Our Ref: HM/7385

Proposal: 14/02004/HYBRID | OUTLINE:- Up to 1500 dwellings, including affordable housing and up to a 150 unit care village (C2) with associated publicly accessible ancillary facilities; site for a new primary school; up to 930sqm of retail space; up to 7,500sqm locally led employment (B1/B2/B8) including link and ride; site for a football association step 5 football facility with publicly accessible ancillary facilities; public open space, associated infrastructure, engineering and ancillary works, (all matters reserved except for means of access to the development); and Full Planning:- development of Phase 1 at the south western corner of the site for the erection of 29 residential dwellings (29 or the 1500 described above) with associated open space, parking and landscaping; with vehicular access provided from Upper Campsfield Road (A4095), Shipton Road and Oxford Road (A44) | Land South Of Perdiswell Farm Shipton Road Shipton On Cherwell

I have been instructed to write to you on behalf of Woodstock Town Council (WTC) to object to this application. In short the proposal is plainly contrary to national planning policy and policies within both West Oxfordshire's

JOB TITLE		Woodstock East		CLIENT		Pye Homes & Vanbrugh Trust	
DRAWING TITLE							
Proposed 45m Roundabout Access							
SCALE	DRAWN BY	DATE	DRAWING No	REVISION			
1:1000@A3	BP	Sept14	15291-21	A

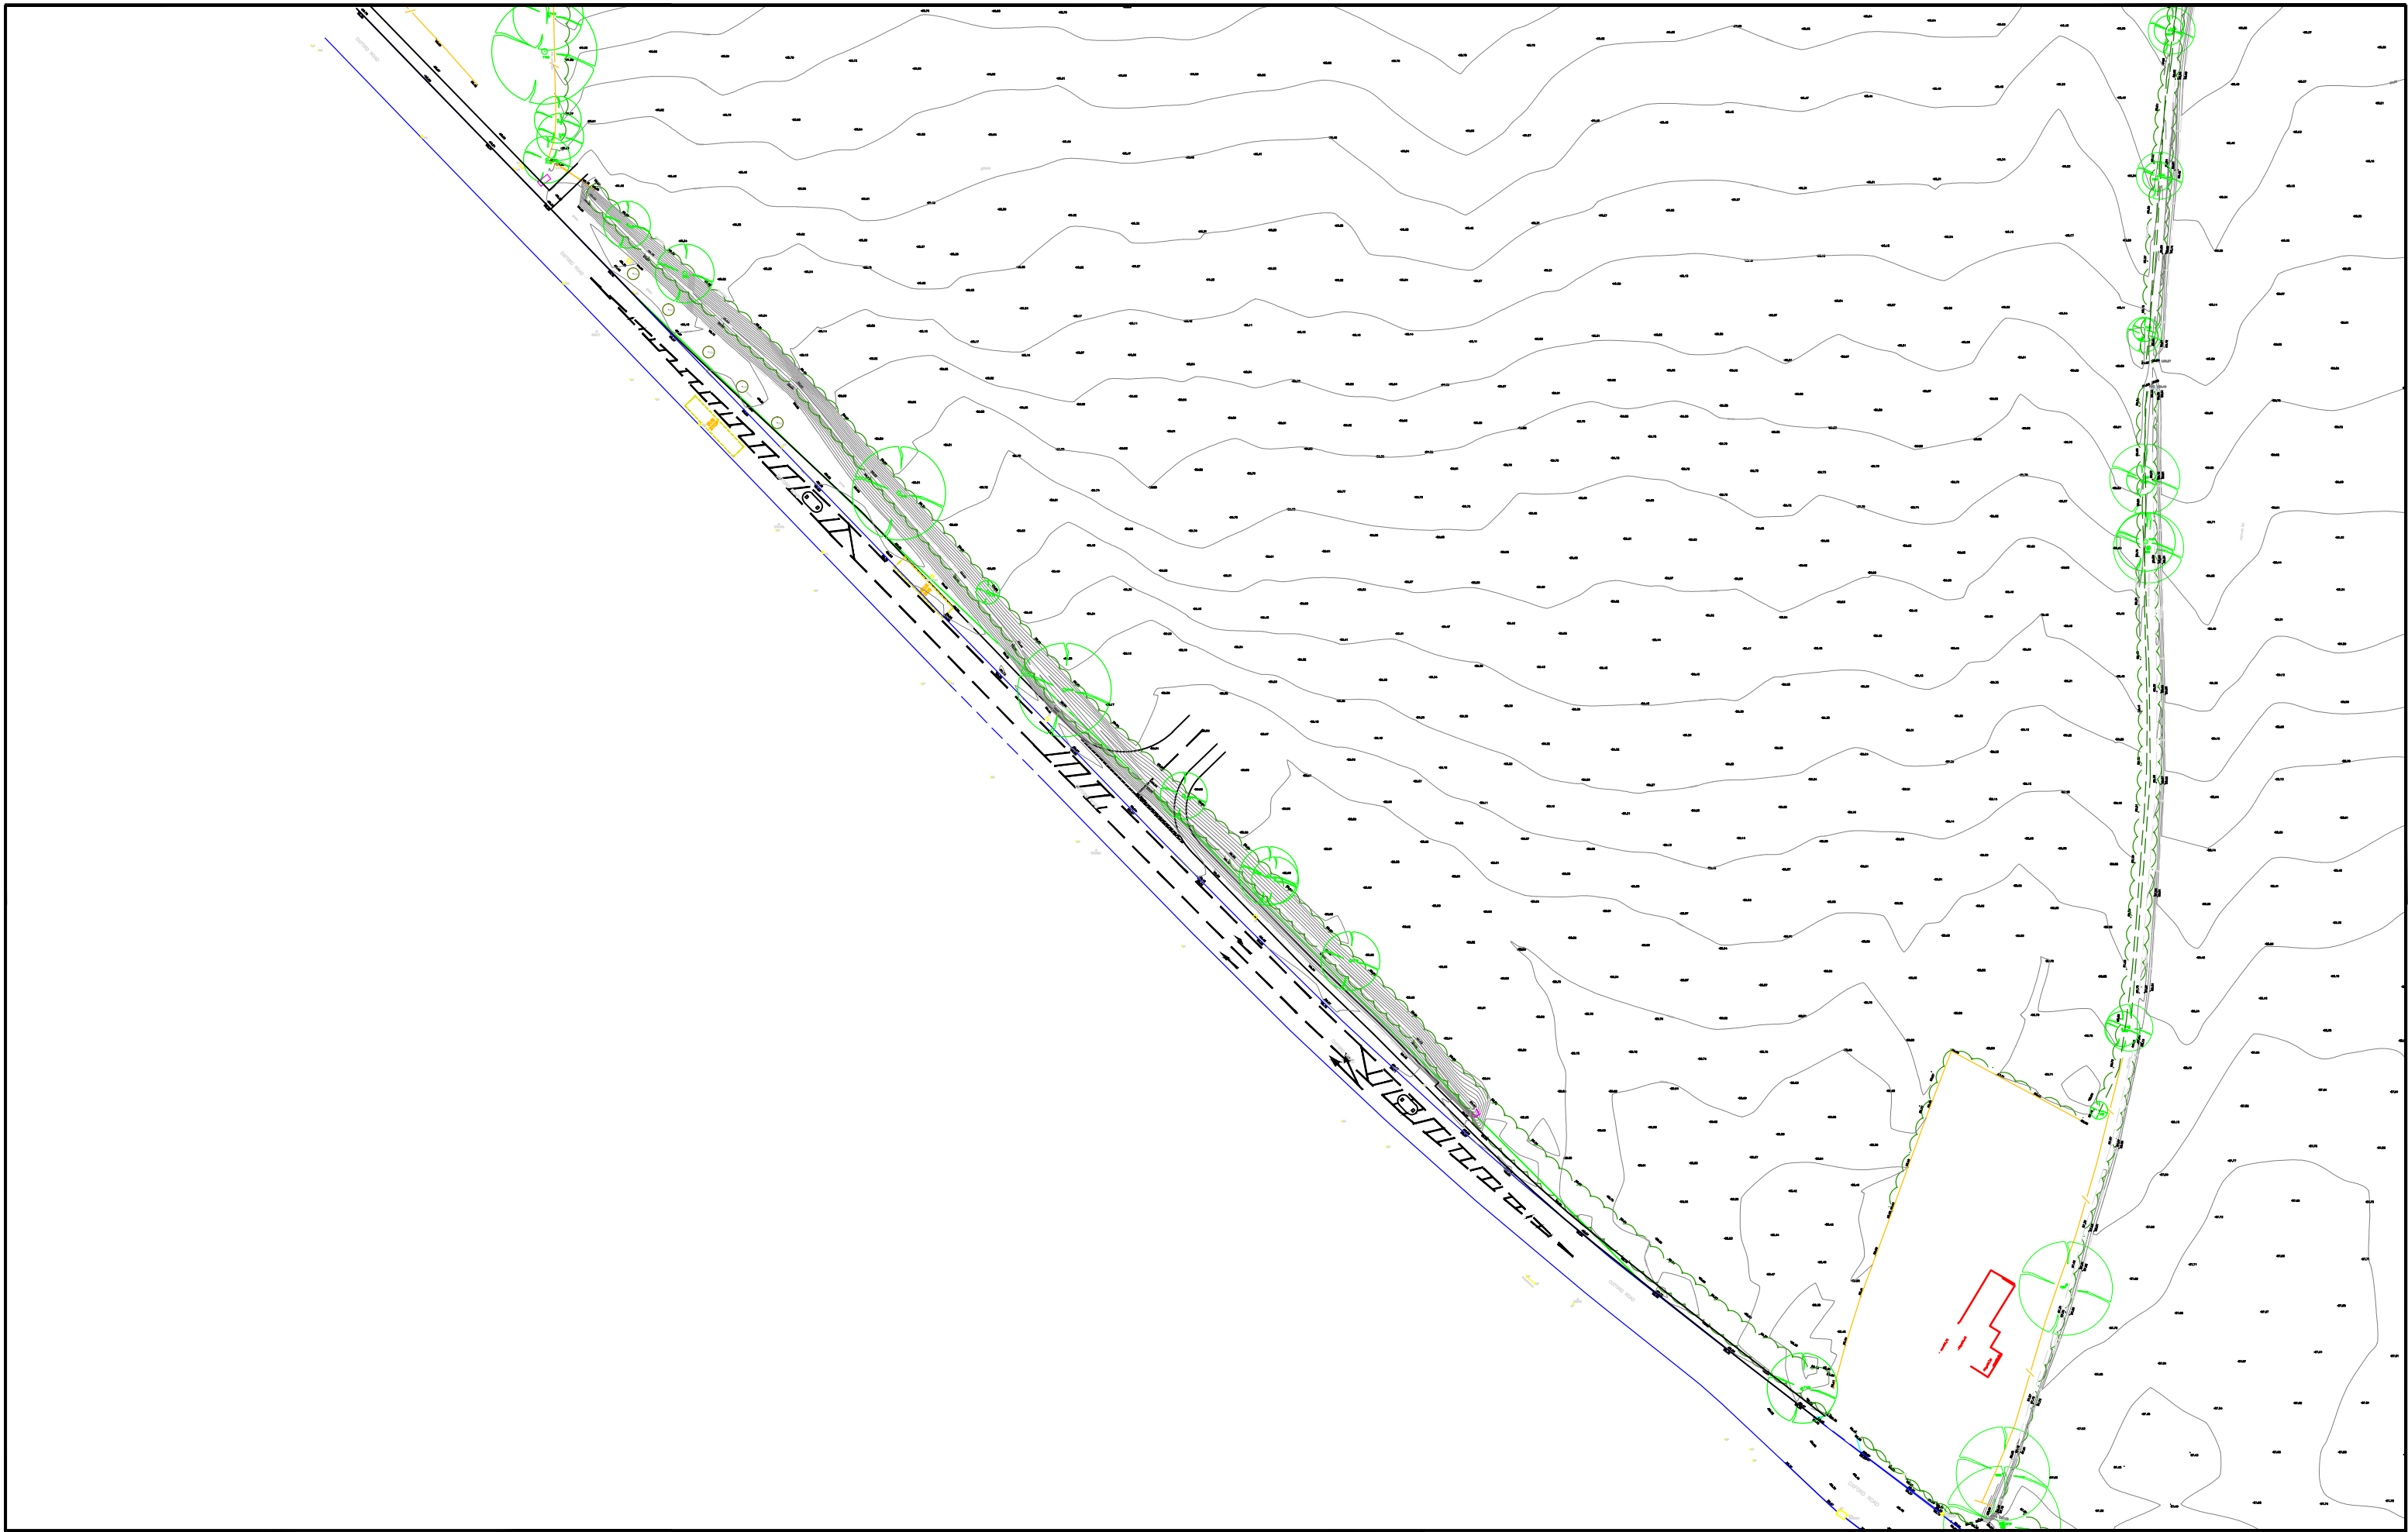
- The proposed new main site access / A4095 Upper Campsfield Road roundabout design does not appear to conform to DMRB standards in terms of IDC / island ration – the A4095 approach road alignments are considered poor.

JOB TITLE		Woodstock East		CLIENT		Pye Homes Vanbrugh Trust	
DRAWING TITLE							
Proposed A44 site access							
SCALE	DRAWN BY	DATE	DRAWING No	REVISION			
1:1000@A3	BP	Sept14	15291-22	B

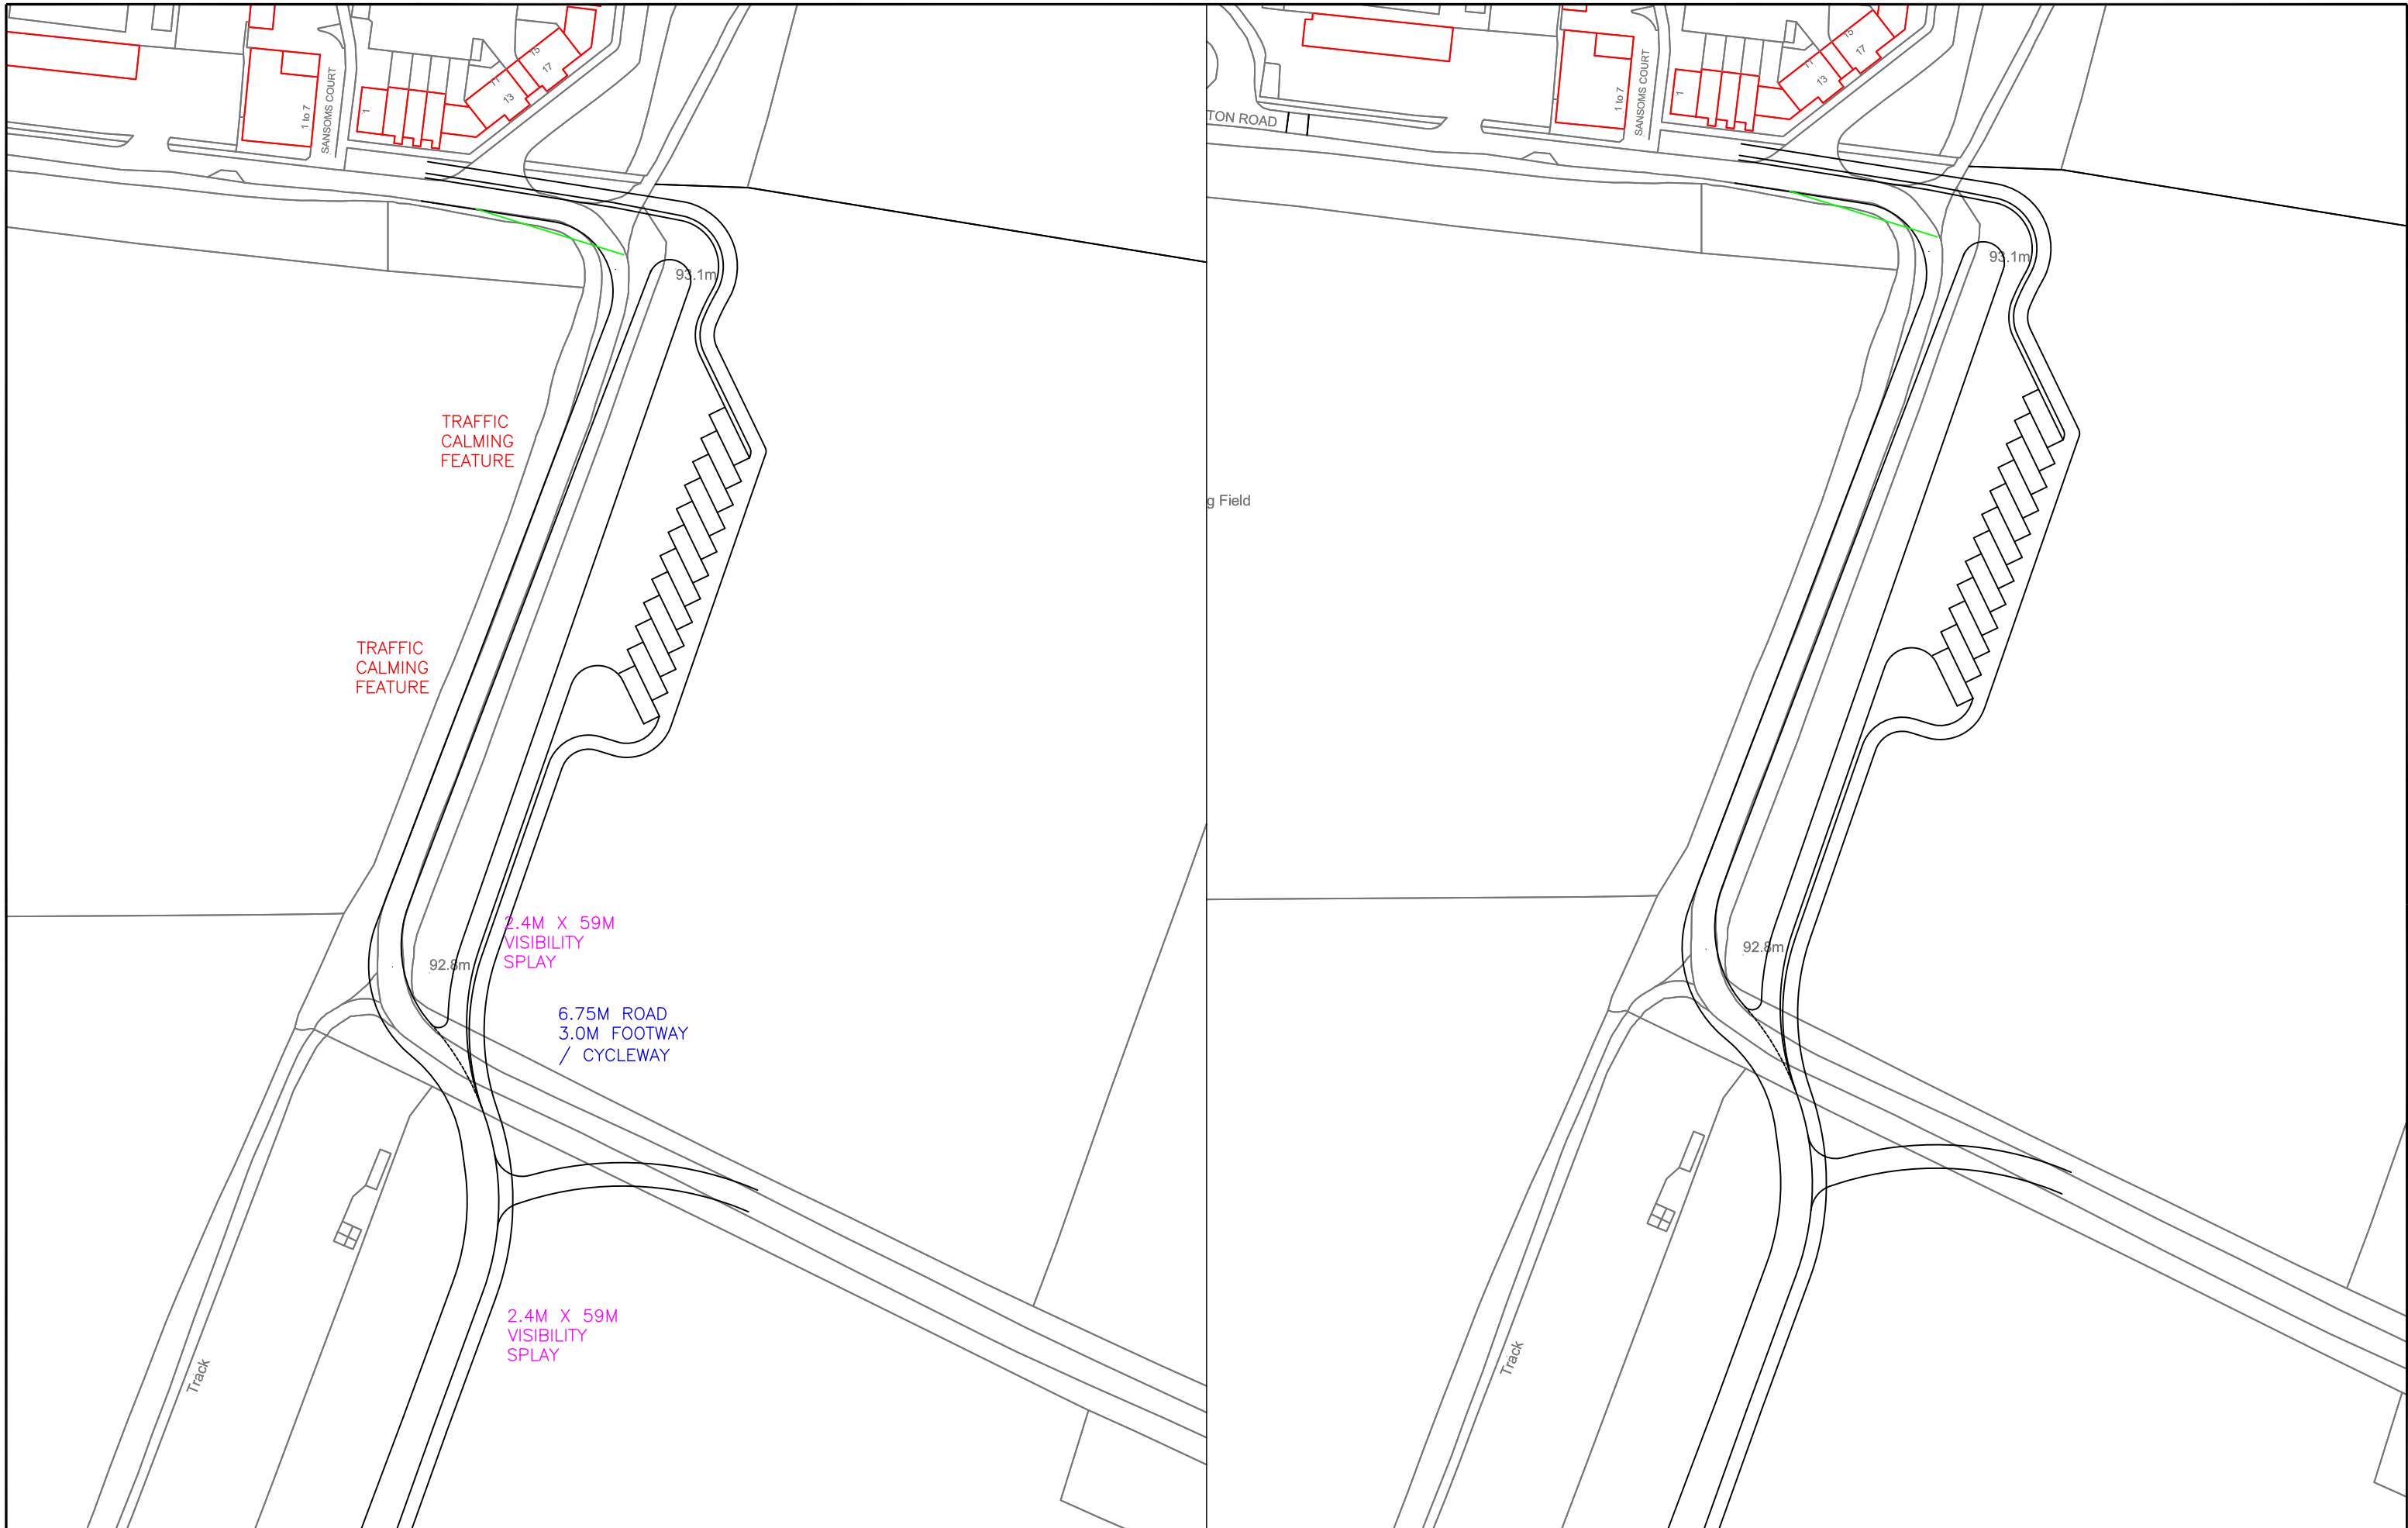
- The proposed right hand turn junction with the A44 appears to be too close to the existing private access on the opposite side to accord with DMRB guidance.
